Date: 1 December 2023
Our Ref: 23/01024/FULHH
Please ask for: Mrs Hannah Roper

Invalid Application

Proposal: Two storey side extension, with single storey porch extension and new boundary fence
Location: 59 Cloughton Avenue Clayton-Le-Woods Leyland PR25 5TJ
Reference: 23/01024/FULHH

Elevation of Fence

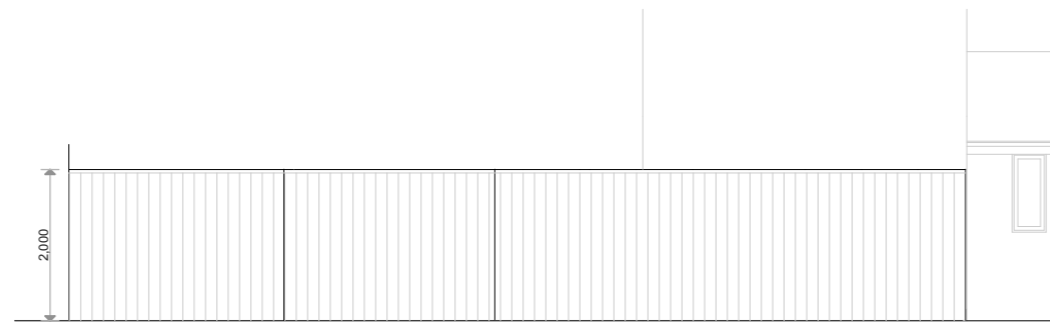
- Red Line Location Plan with two annotated road names
- Elevational Drawings showing the proposed fence.
